REFUSAL OF PLANNING PERMISSION

APPLICATION NO. 2019/0960

Proposal Outbuilding to be used for domestic storage purposes
At 4 Burton Crescent, Monk Bretton, Barnsley, S71 2QD

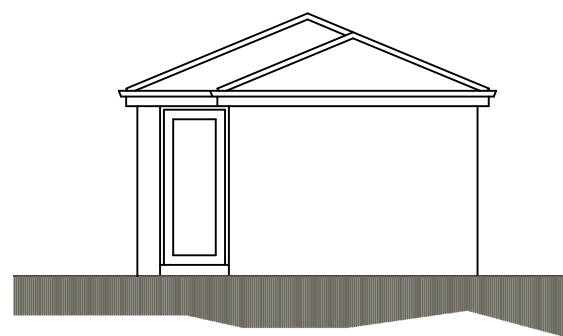
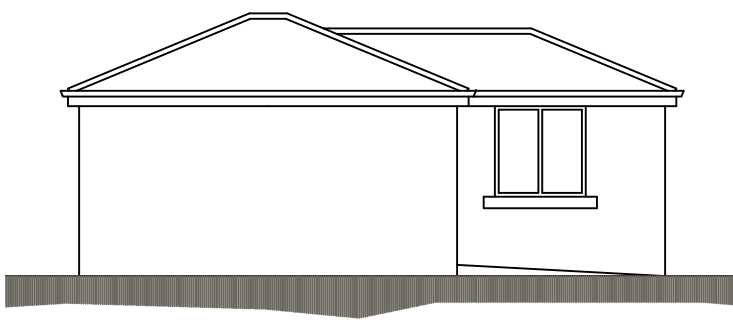
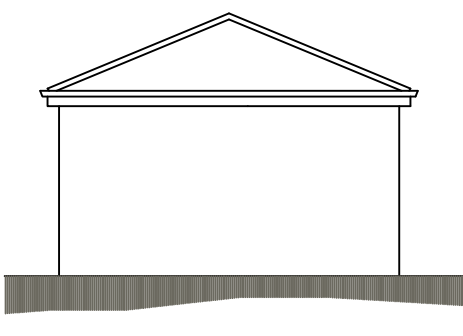
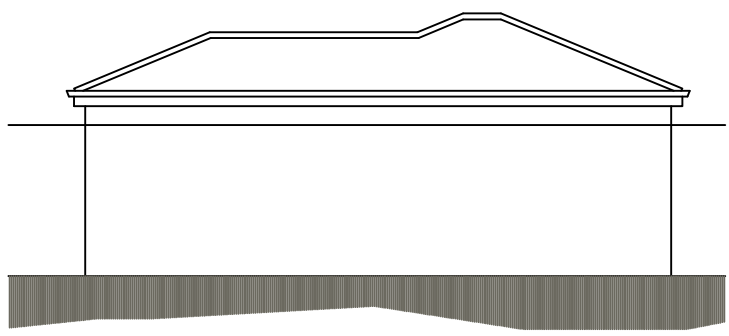
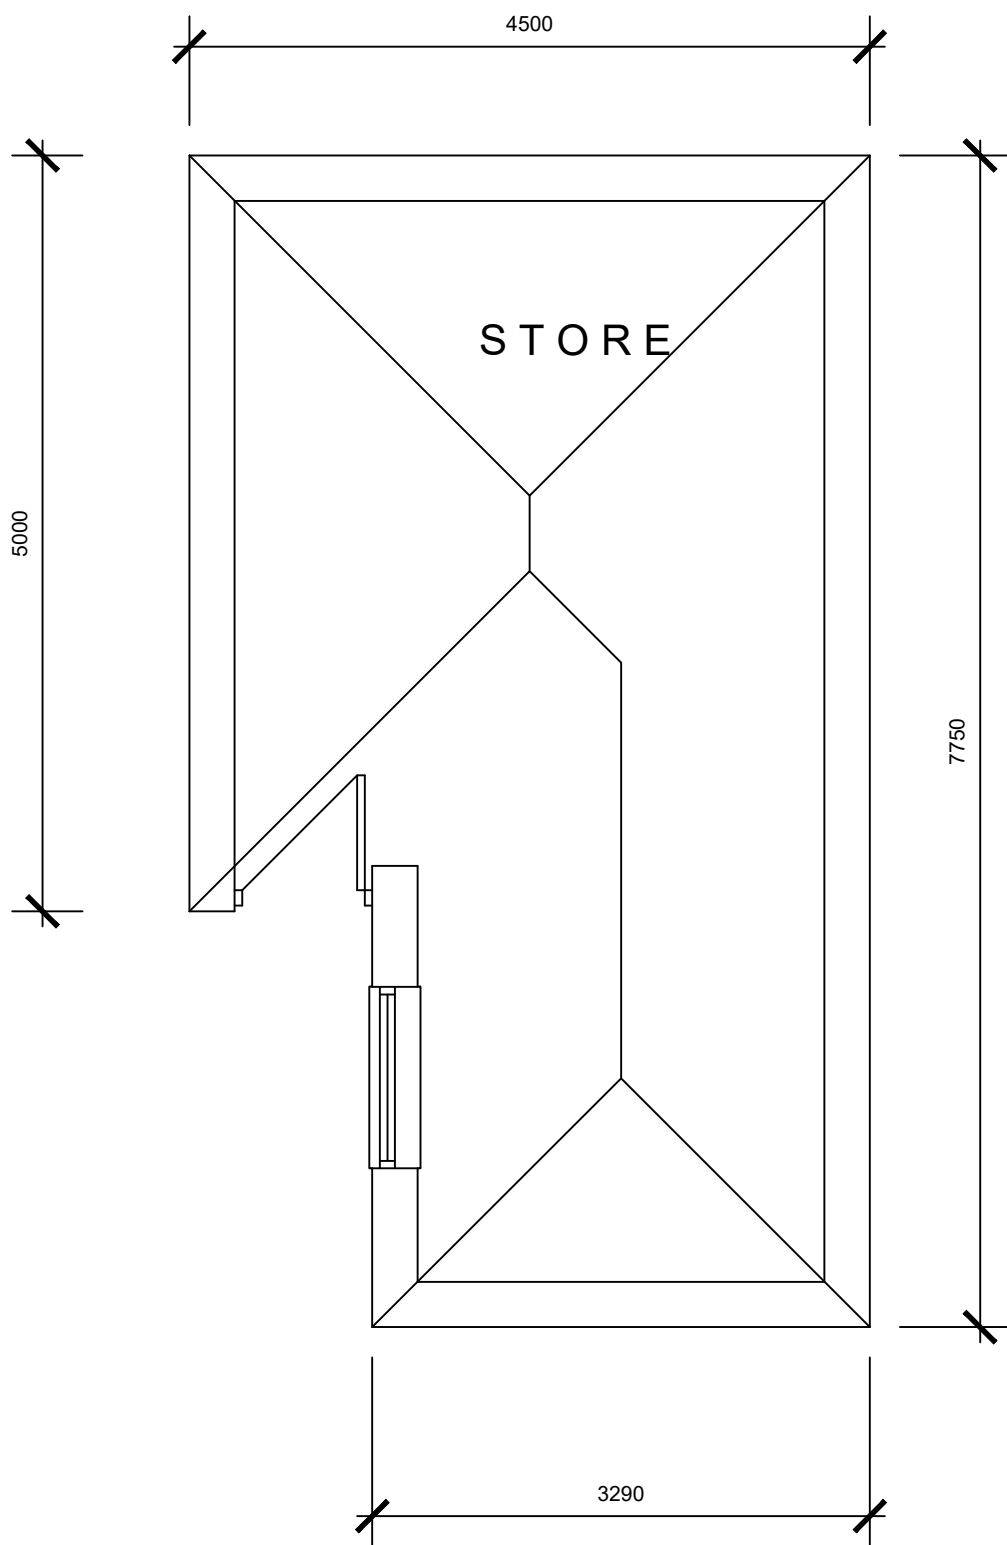
- 1 In the opinion of the Local Planning Authority the proposed outbuilding would appear unduly dominant in the rear garden and would draw attention to itself as an incongruous feature that would be out of character with the smaller scale outbuildings located in the adjoining gardens and the open and spacious character of its surroundings. In addition the development would be harmful to the amenities of the occupants of the adjoining dwellings due to it appearing overbearing in context and it resulting in overshadowing of the private rear gardens of adjacent properties. The proposal is therefore contrary to Local Plan Policy GD1 'General Development', Local Plan Policy D1 'High Quality Design and Place Making' and the Council's House Extensions and Other Domestic Alterations Supplementary Planning Document.
